**WELWYN HATFIELD BOROUGH COUNCIL
EXECUTIVE DIRECTOR - PLANNING, PUBLIC PROTECTION AND GOVERNANCE**

DELEGATED APPLICATION

Application No: 6/2020/1325/FULL
Location: Land Adjacent to 48 The Ridgeway, Cuffley, Potters Bar, EN6 4BA
Proposal: Erection of detached dwelling and new vehicular access
Officer: Mr David Elmore

6/2020/1325/FULL

Lower Ground Floor Plan

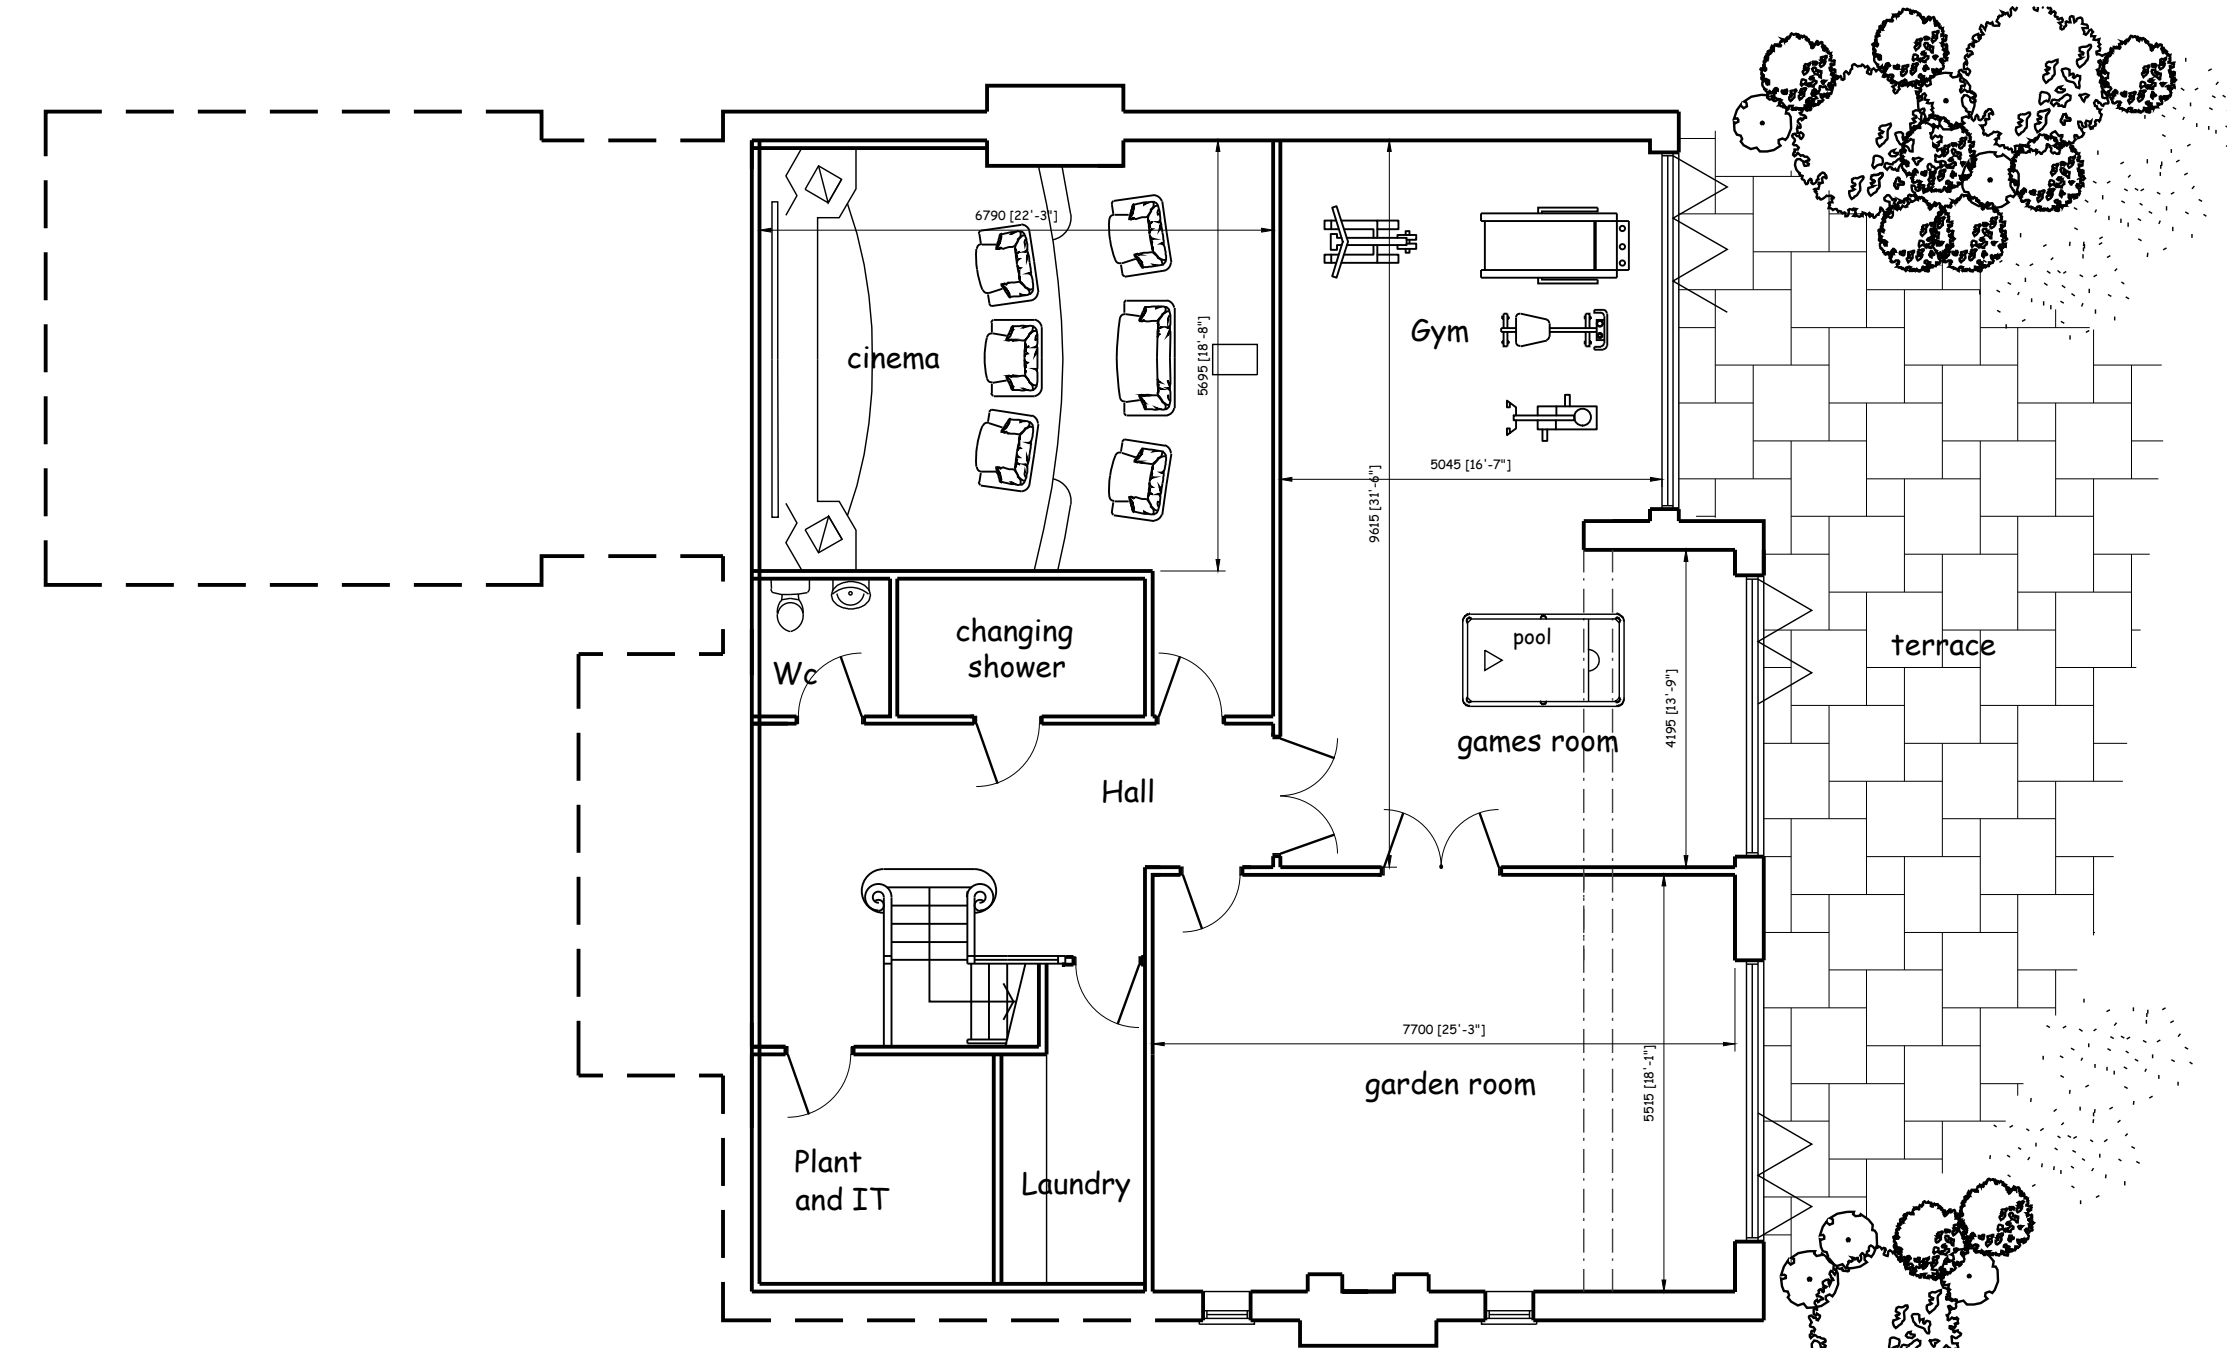
The dwelling would be faced in a mix of timber boarding and brickwork below a natural slate tile roof. Having regard to the variety of materials used on dwellings in the area, the principle of the proposed materials are acceptable. The use of timber boarding in the background behind retained boundary landscaping would further make the dwelling and its size less apparent.

Upper floor side facing windows (serving bedroom, dressing room, en-suites) would face flank windows of the two neighbouring properties on either side. All these windows (save for the dormer windows) give rise to potential for overlooking and loss of privacy. To prevent such adverse effects, it is considered necessary and reasonable for these windows should obscure glazed with a restricted level of opening. This measure can be secured through planning condition.

5. The upper floor side windows of the dwelling hereby approved (excluding dormer windows and rooflights) must be obscure glazed; and non-opening (unless the parts of the window which can be opened are more than 1.7 metres above the floor of the room in which the window is installed), and shall be retained in that form thereafter.

Site Plan 1:500 Scale

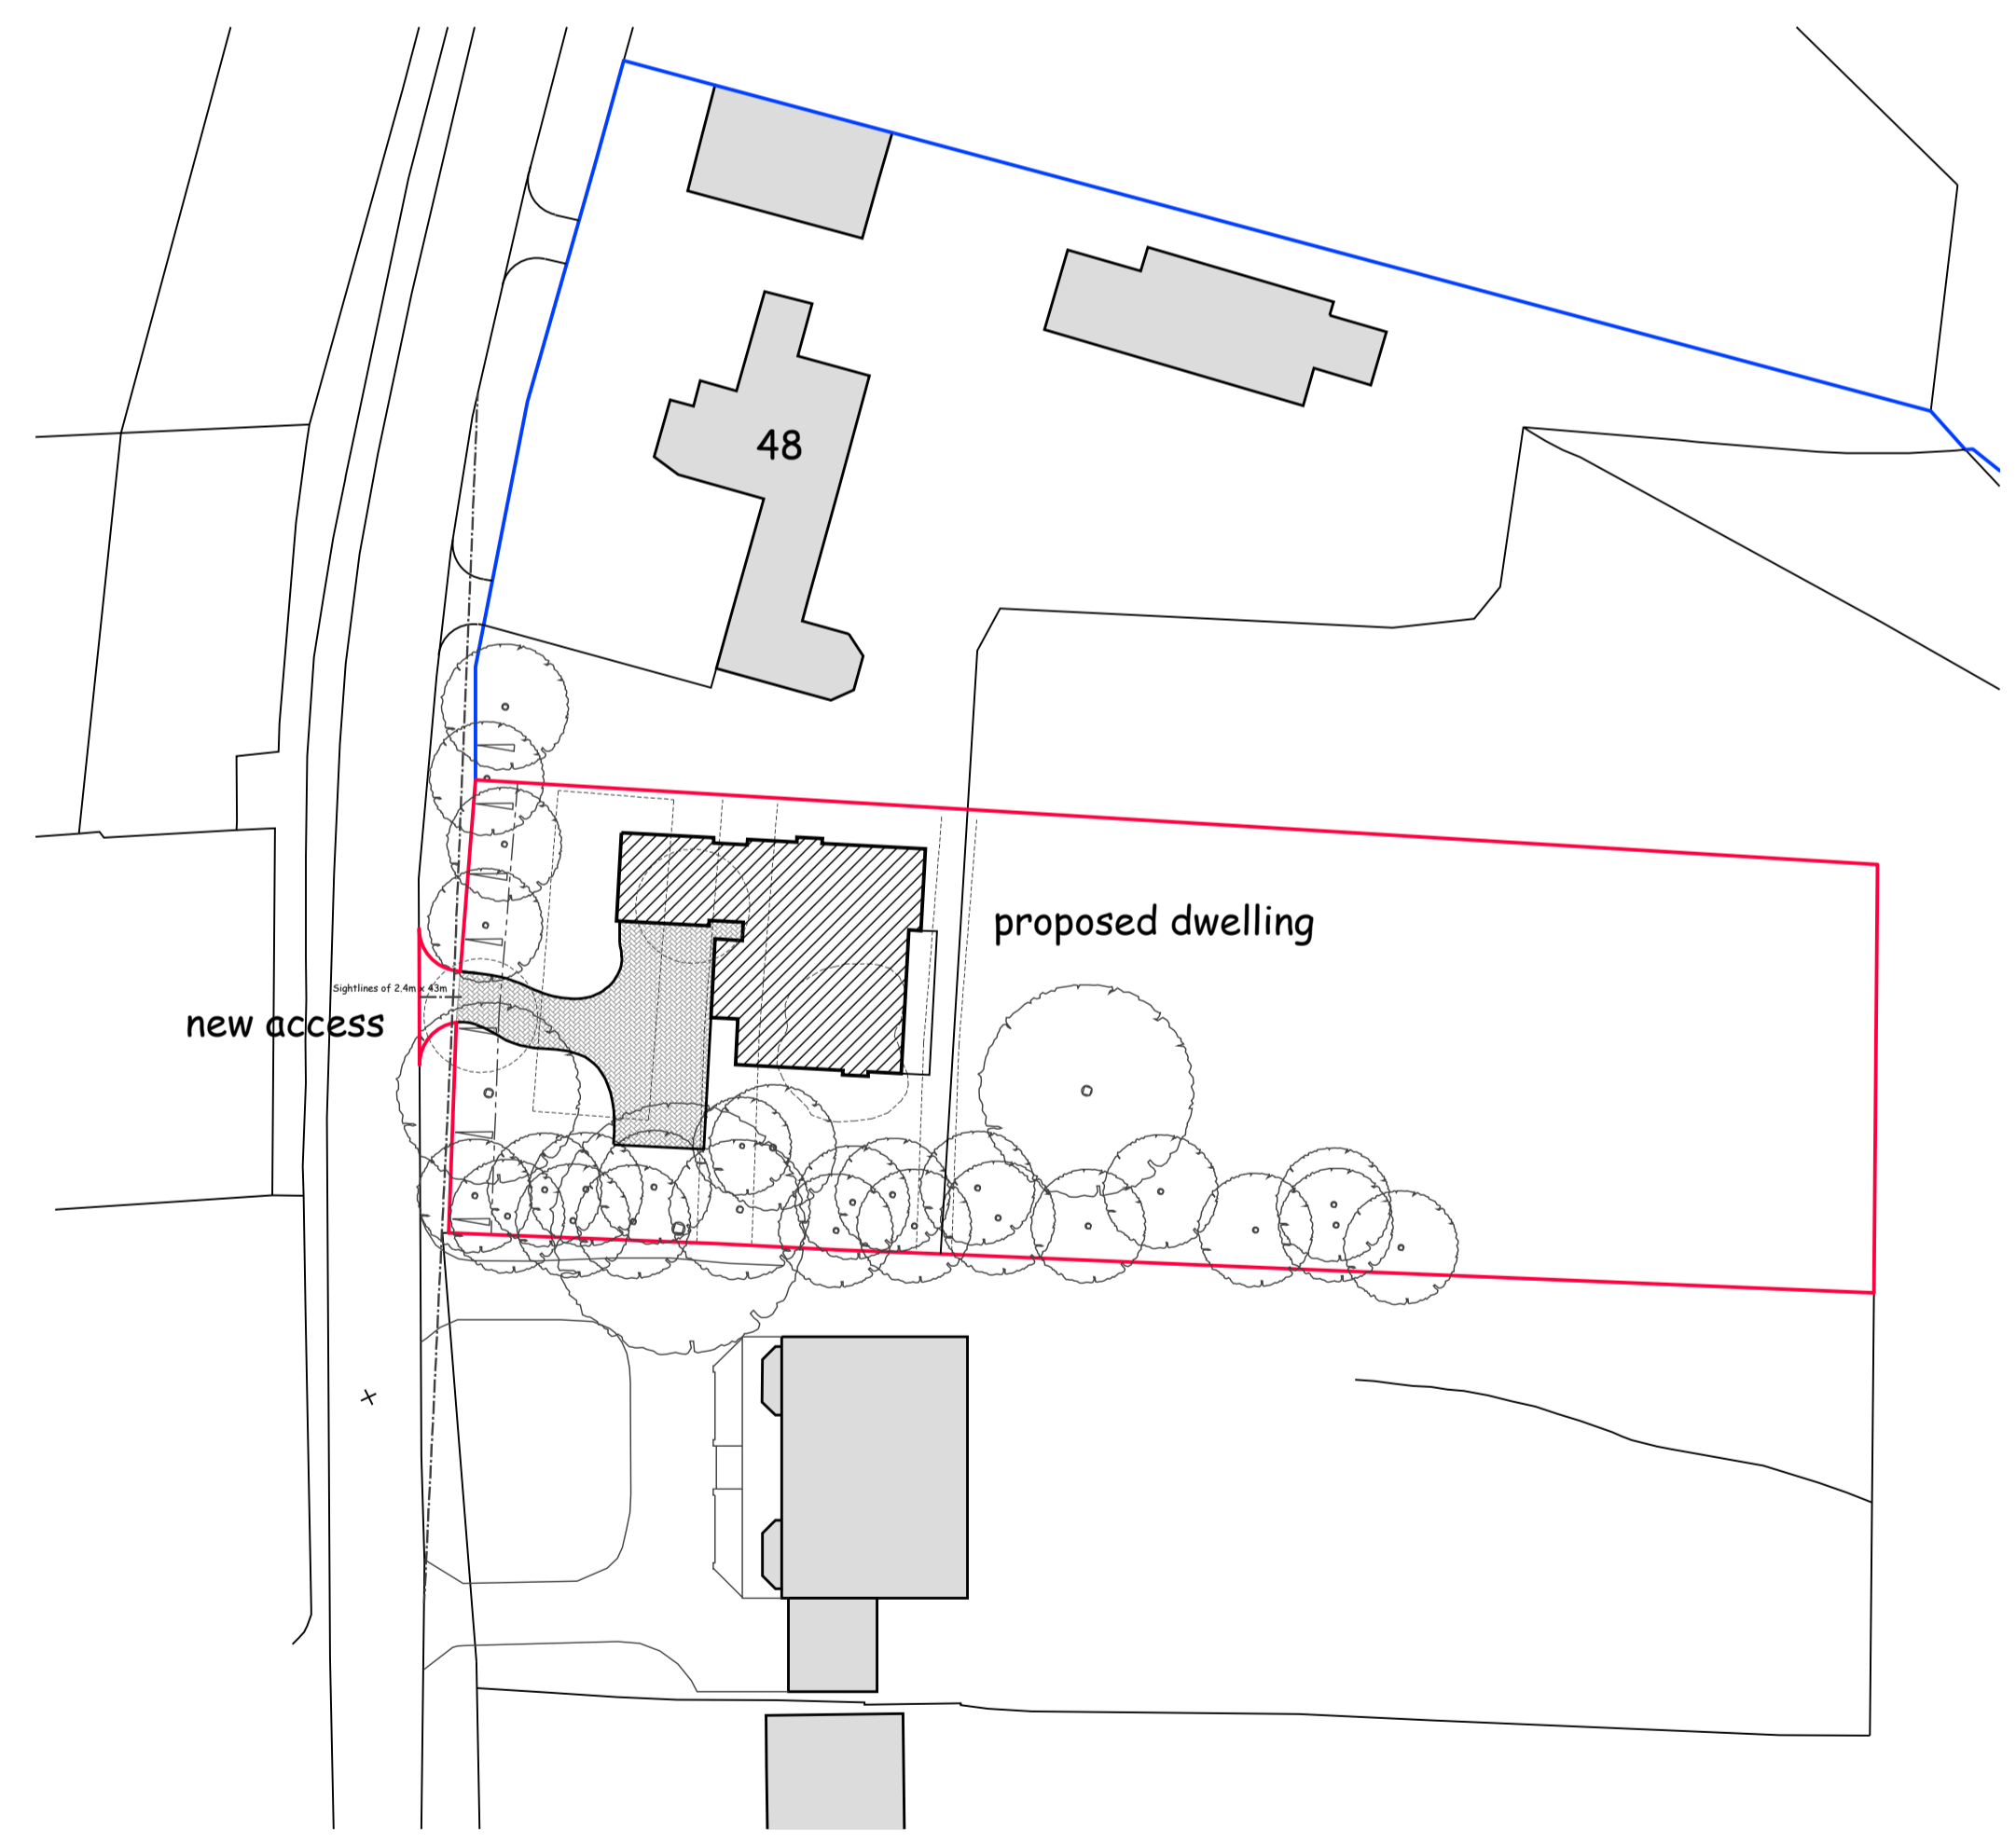
The submitted Design & Access Statement indicates that the proposal would not require the removal of any significant trees from the site and that a new scheme of soft landscaping could be planted. Limited details however have provided. It appears from the proposed site plan that only three existing trees would be removed to facilitate the development – one to provide vehicular access from The Ridgeway and the other two to erect the dwelling. In this case therefore almost all of the boundary landscaping would be retained and this is important to soften the presence of built development and maintain the landscape setting. Precise details of all retained trees and additional planting can be secured through planning condition.

No details of hard landscaping have been submitted. It is reasonable that a driveway would be provided to the front of the property and the proposed site plan gives indication to this. Details of hard landscaping can be secured through planning condition. This will ensure that an appropriate balance of soft to hard landscaping is achieved in keeping with the area.

The proposal would also involve sub-division and delineation of the existing plot. Suitable hard boundary treatments can be secured through planning condition to ensure the privacy of 48 The Ridgeway is maintained.

2. No development above ground level in any phase of the development shall take place until full details on a suitably scaled plan of both hard and soft landscape works have been submitted to and approved in writing by the Local Planning Authority. The development shall not be carried out other than in accordance with the approved details.

6. Prior to the first occupation of the development hereby permitted the vehicular access must be provided and thereafter retained at the position shown on drawing number 1395-P002-A. Arrangement must be made for surface water drainage to be intercepted and disposed of separately so that it does not discharge from or onto the highway carriageway.
